Demolition of 1 No. existing house & grounds & erection of 2 No. new detached dwellings. This application may affect the character & appearance of the Station Road, East Preston Conservation Area.

St Marys Close Hurst Road Rustington

Thank you for your internet representation made on 26th September 2018 which has been recorded as '**an objection**' with the comments as follows:

Drawing Title:
ADDITIONAL DWELLINGS
BLOCK/ SITE PLAN

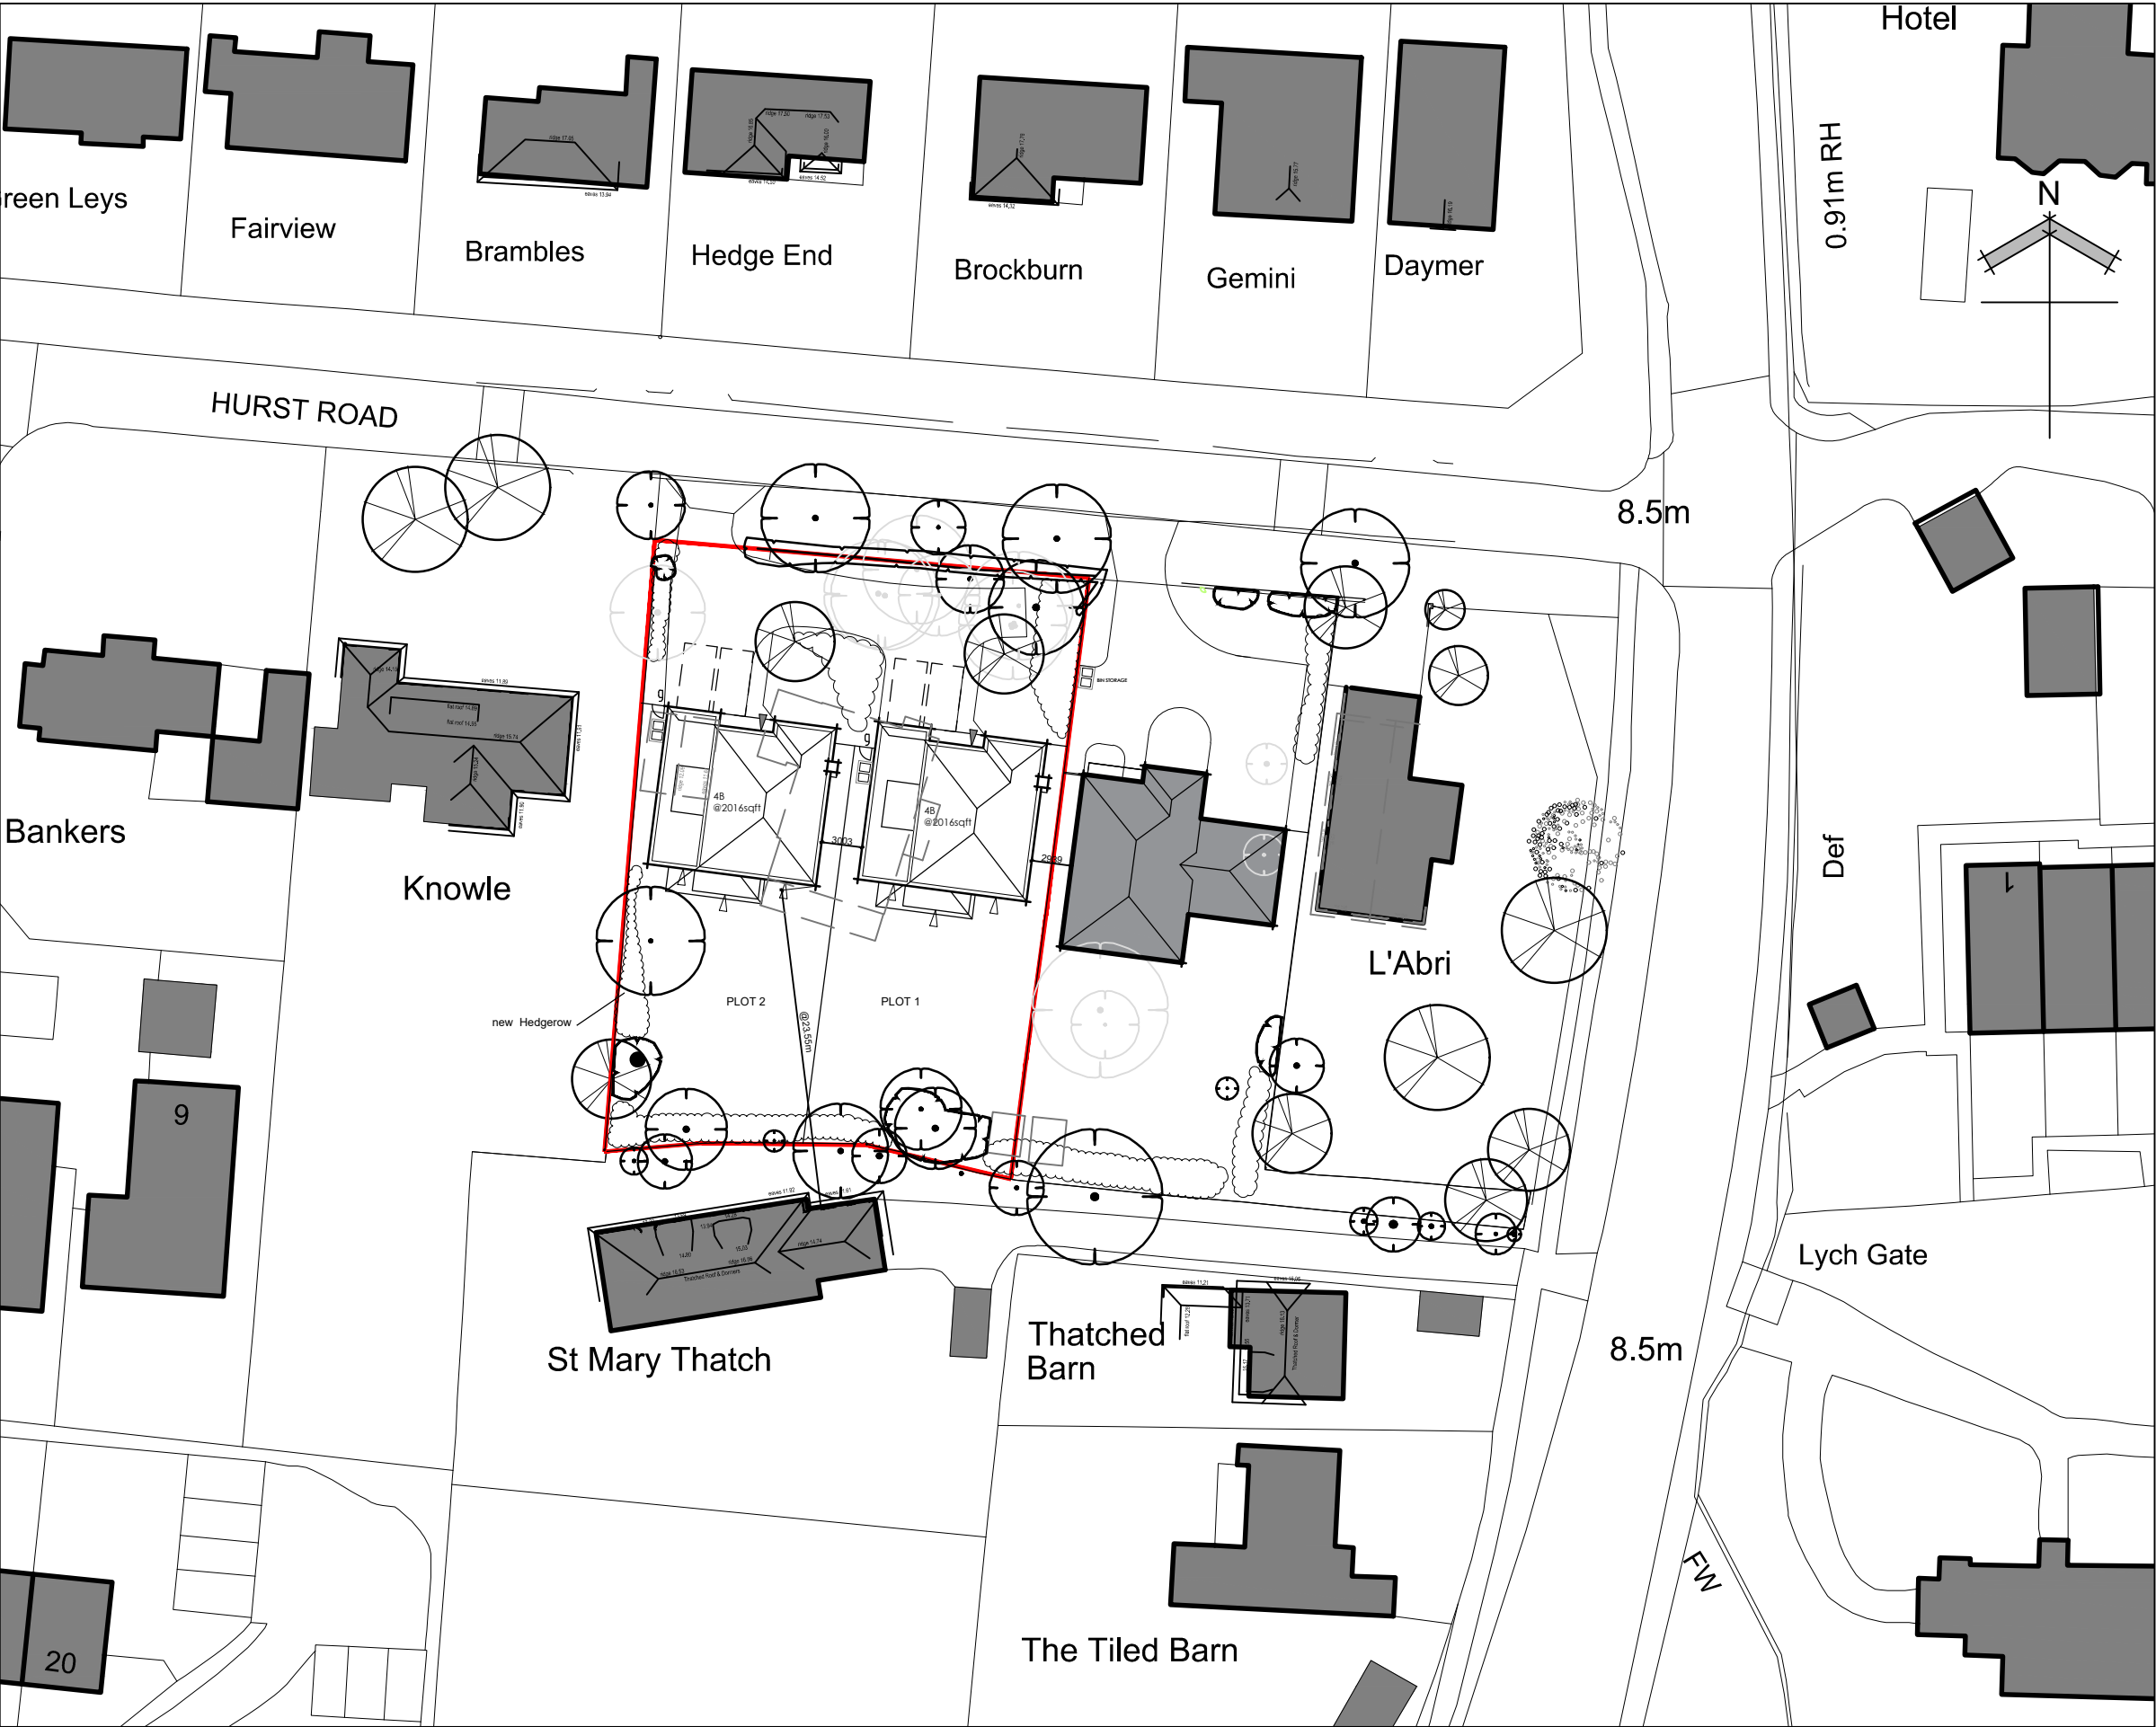
We would also request that the trees in the border to the front of the site are preserved. The lime and hawthorn trees are planted the length of Hurst Road giving a distinct character.

Drawing Title:
ADDITIONAL DWELLING
PLOTS 1 & 2
ELEVATIONS

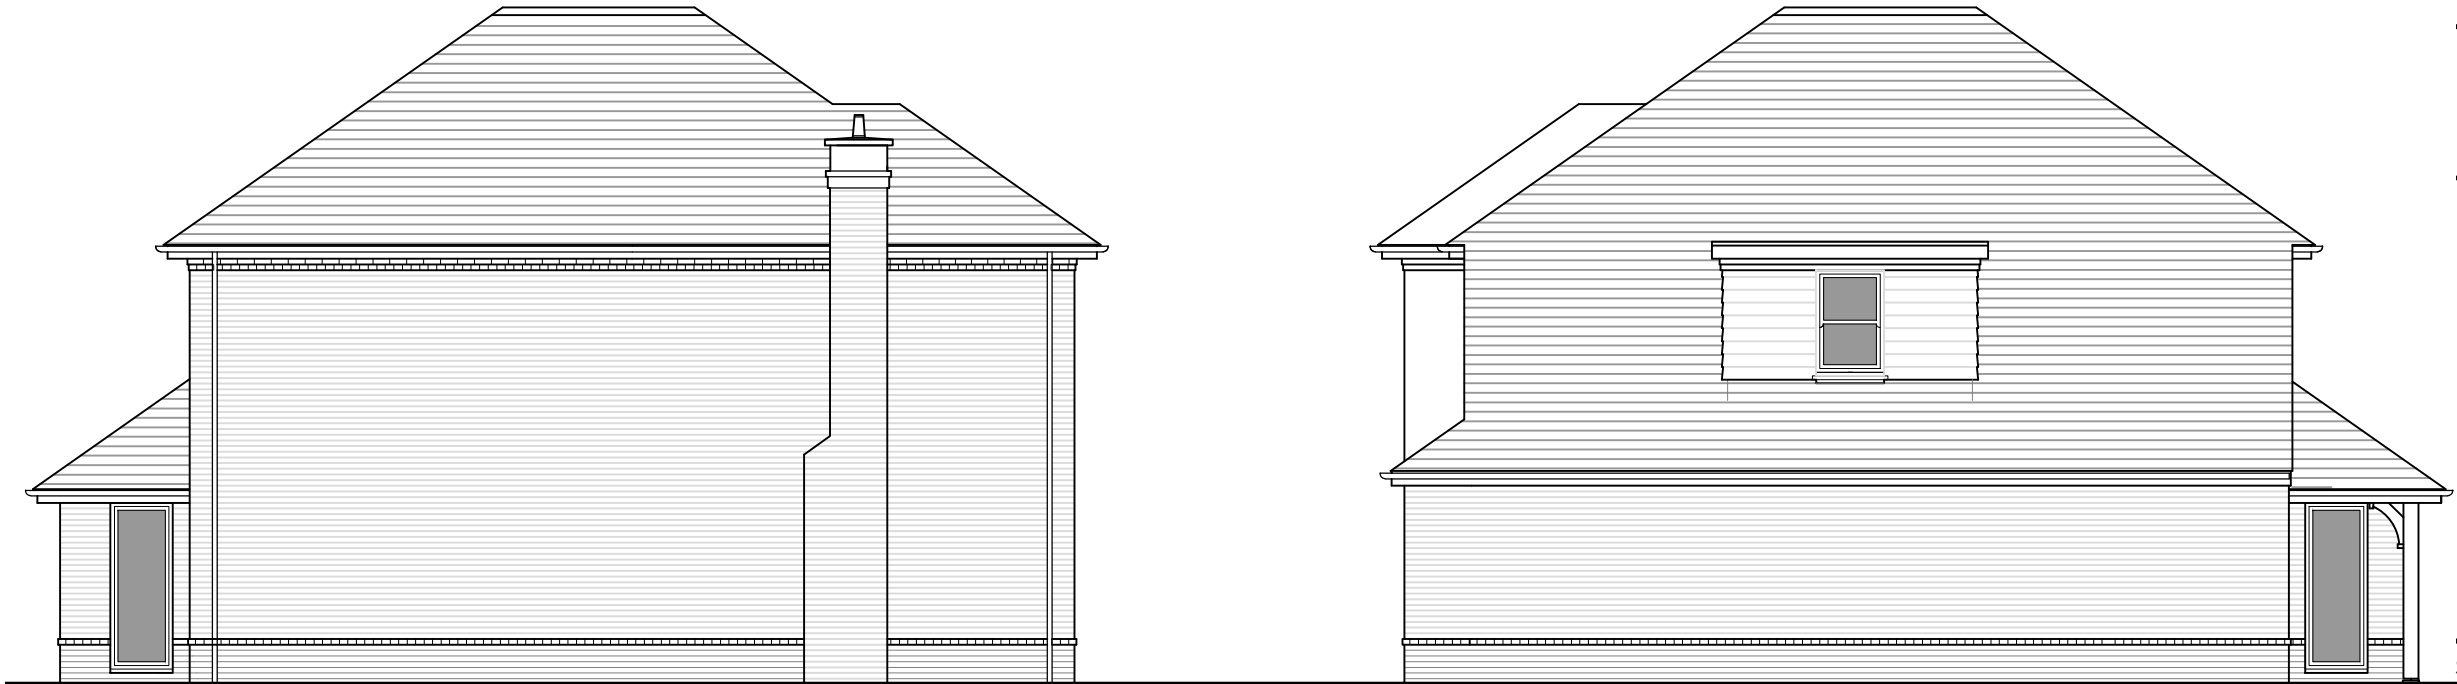
Reference is made to application R/64/17/PL which was for 4 properties on the same site. One of the principal objections we made then was based on the 4 properties being virtually identical unlike the rest of Hurst Road. Lack of this 'unique' aspect was cited in the Authority's rejection of that application. Unfortunately the plans for the latest application for 2 properties shows a pair of identical buildings. Therefore, the same objection is lodged here.
